City of Albuquerque Stormwater Construction Site Inspection Report

General Information					
ESC File No.	M09E032	Project Name:	Sombra del Oeste		
NPDES Id. No.	NMR1005WH	Location:	Gibson Blvd and Valley Cottonwood SW		
12/5/2024	Owner		Contractor		
Operator	Homewise Inc.				
Contact name & title	Eugene Chavez				
e-mail	echavez@homewise.org				
Contact Phone #	505-983-9473				
COA Inspector	James Hughes		Start/End Time:	10am	
Construction Phase:	Earthwork and Utilities.				
Type of Inspection:	<input checked="" type="checkbox"/> Regular	<input type="checkbox"/> Storm Event	<input type="checkbox"/> Post Storm Event >0.25"	<input type="checkbox"/> 311/Complaint	<input type="checkbox"/> Follow Up
Weather at time of inspection?		Clear		Temperature: ~	43
Estimated date of last storm 0.25" or greater		11/7/2024

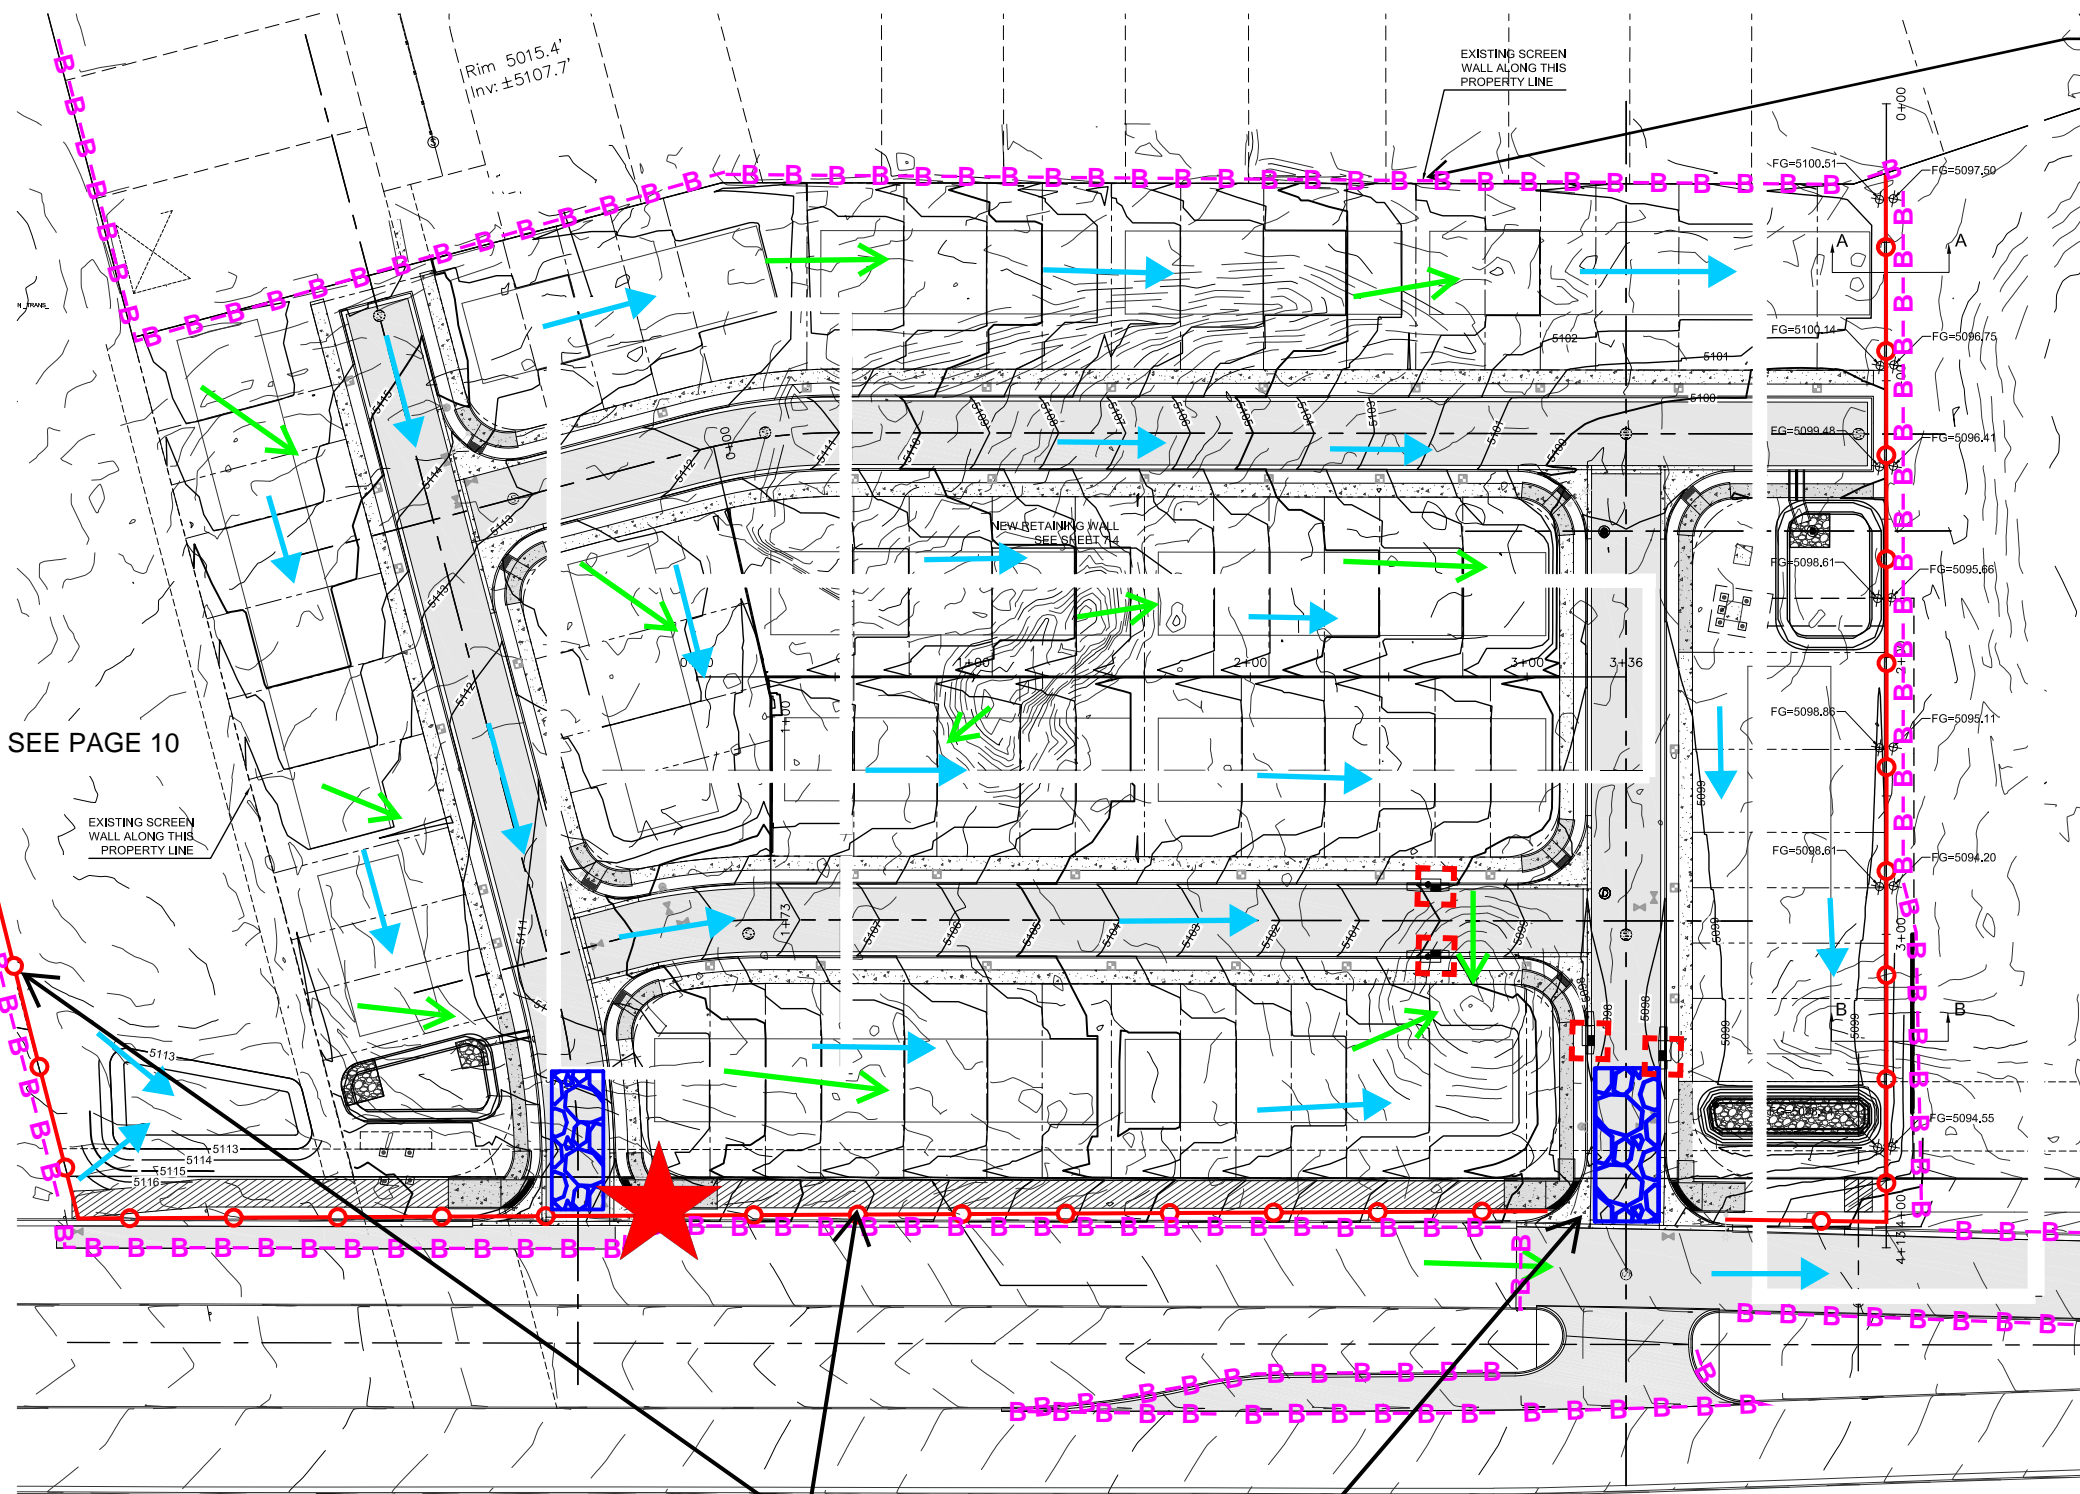
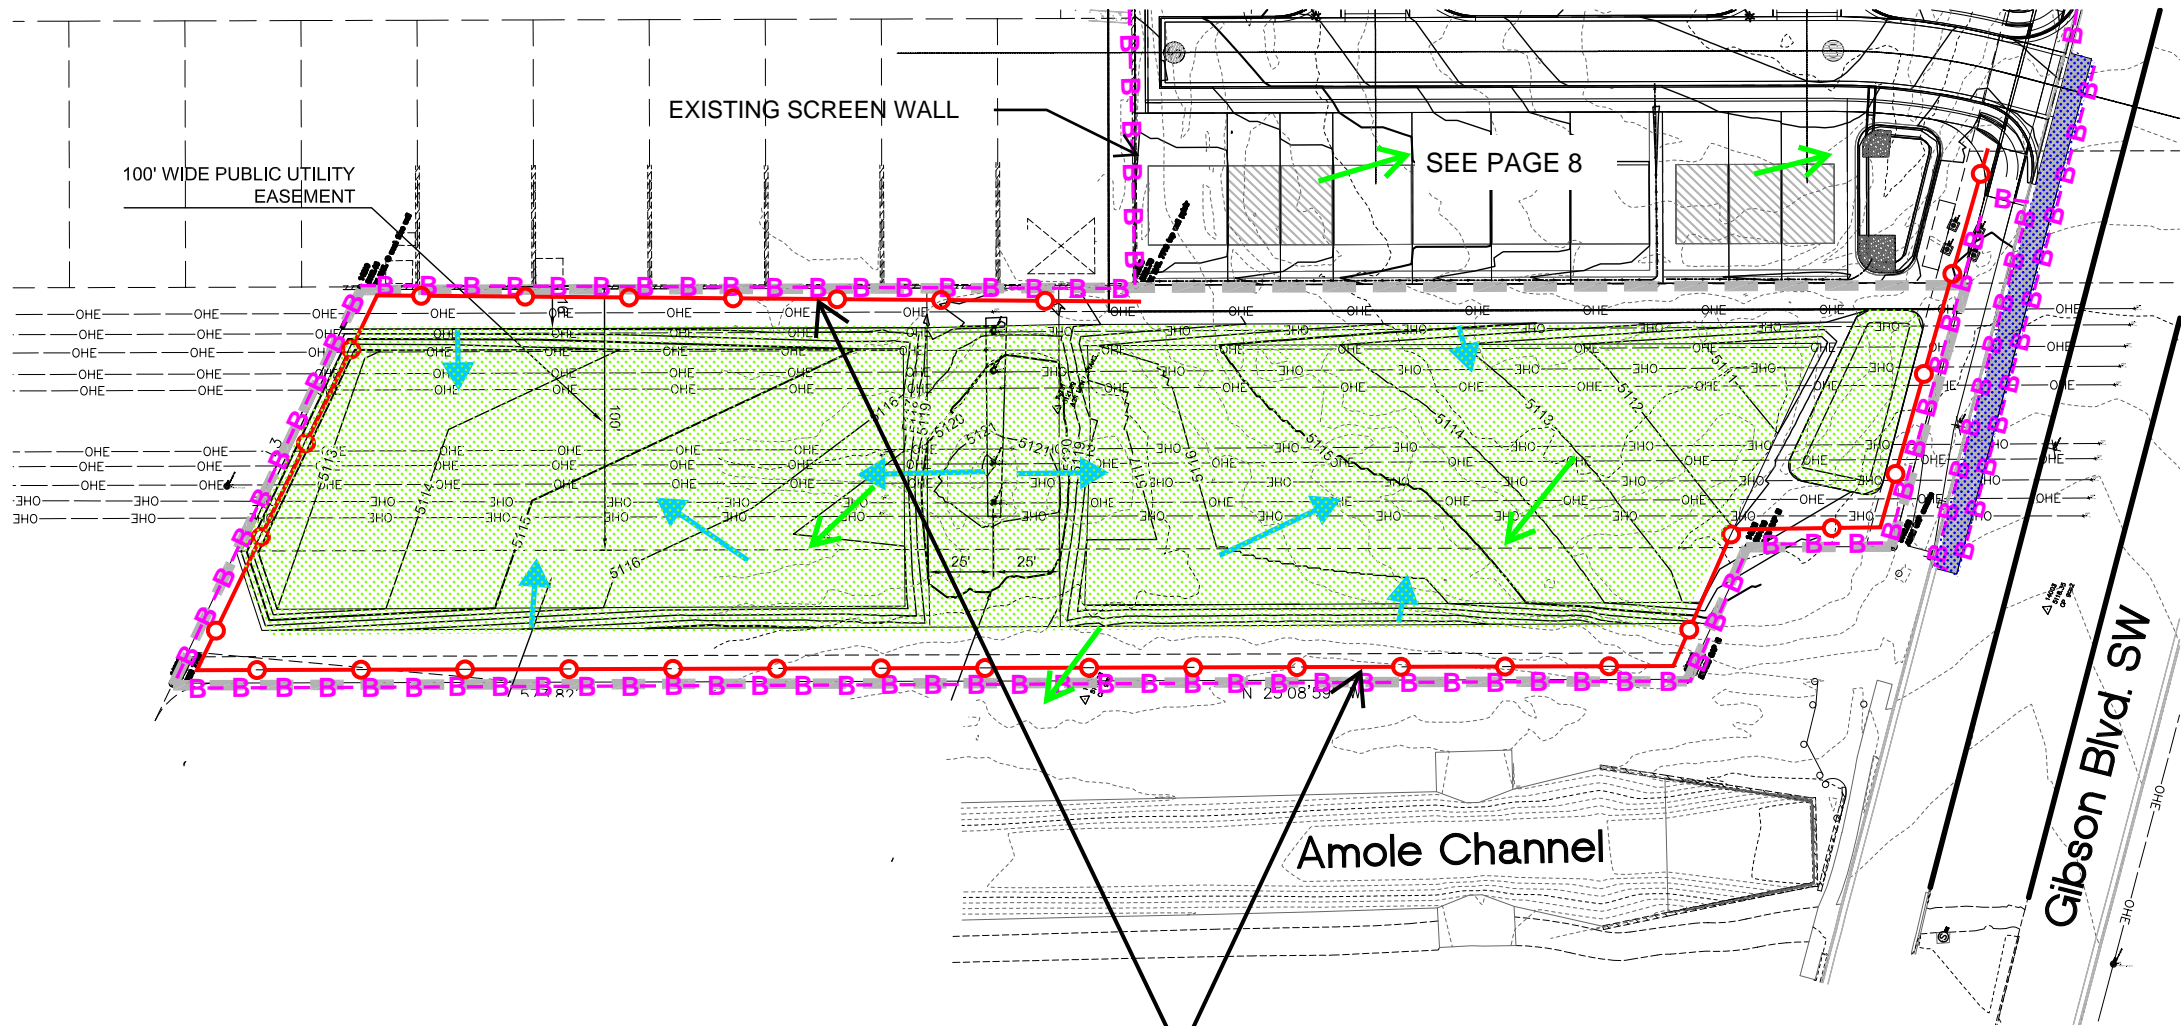
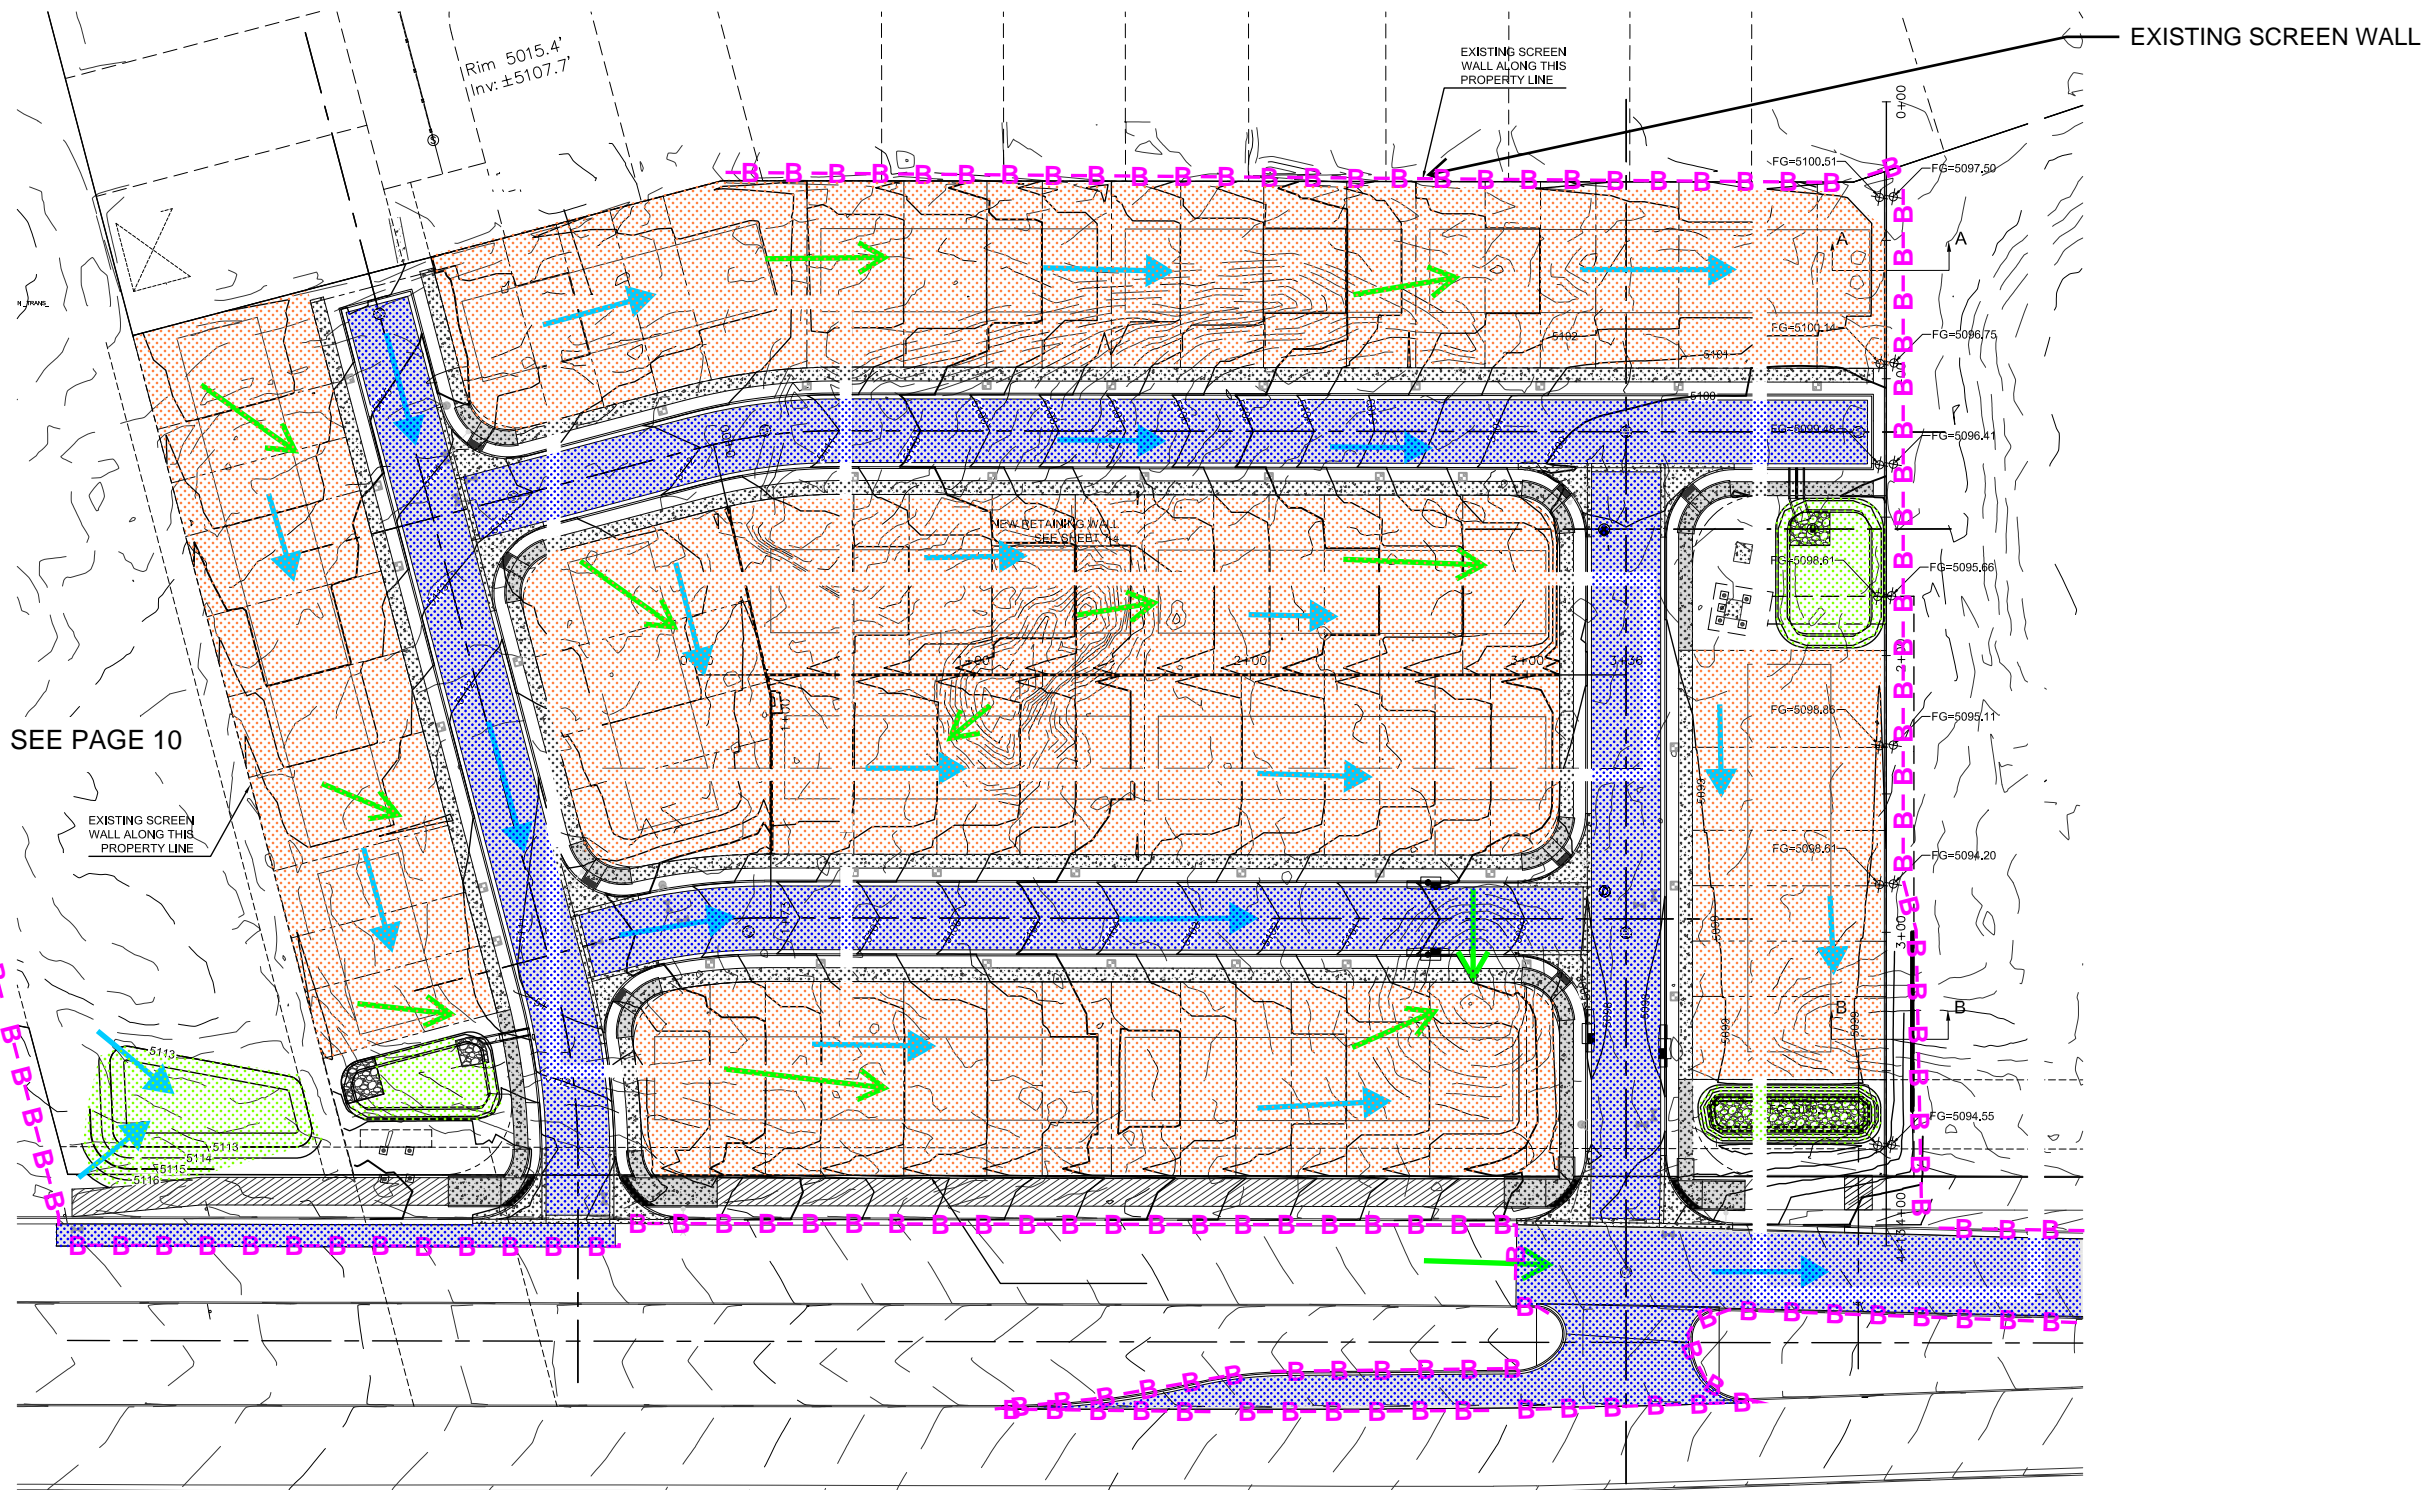
BMPs - Stormwater controls were missing from Gibson Blvd and temporary sediment basins were missing at the onsite locations of Ponds B & C in violation of CGP 2.1.2 and 2.1.3. The Inlet Protection (IP) was missing in Gibson in violation of CGP2.2.10, and additional controls must be added at the low edge of the disturbed portions of Gibson per CGP 2.2.3. Onsite temporary sediment basins (SB) don't have adequate volume in violation of CGP 2.2.12. Required mitigation: Ensure that all stormwater controls (BMPs) are maintained and remain in effective operating condition during permit coverage per CGP 2.1.4. If at any time you find that a stormwater control needs routine Maintenance, you must immediately initiate the needed maintenance work and complete such work by the close of the next business day per CGP 2.1.4.b. When the problem requires a new or replacement control or significant repair, install the new or modified control and make it operational or complete the repair by no later than seven (7) calendar days from the time of discovery per CGP 5.2.1. Provide inlet protection per CGP 2.2.10, perimeter controls per CGP 2.2.3, and CGP 2.2.5 in Gibson Blvd. Onsite, add temporary sediment basins per CGP 2.2.12. at Ponds B & C until Work Order construction and stabilization are complete. Then Cutback Curbs and Silt Fences (SF) must keep sediment out of the onsite streets per CGP2.2.3.

2.1	Discharge off site? (Y/N)	Yes			
4	Self Inspection Reports	missing	Latest report Date:	missing	
Notes: Pad and Street subgrades were complete, but Ponds B&C were missing.					
The site drained to two concentrate discharge points on the east side of the site, where the only BMP was a few feet of SF. This site cannot discharge any surface drainage. The only allowable discharge is into a city storm drain, and only that portion in excess of the 2-ry-24-hr runoff volume. This site must retain the 2-yr 24-yr volume onsite.
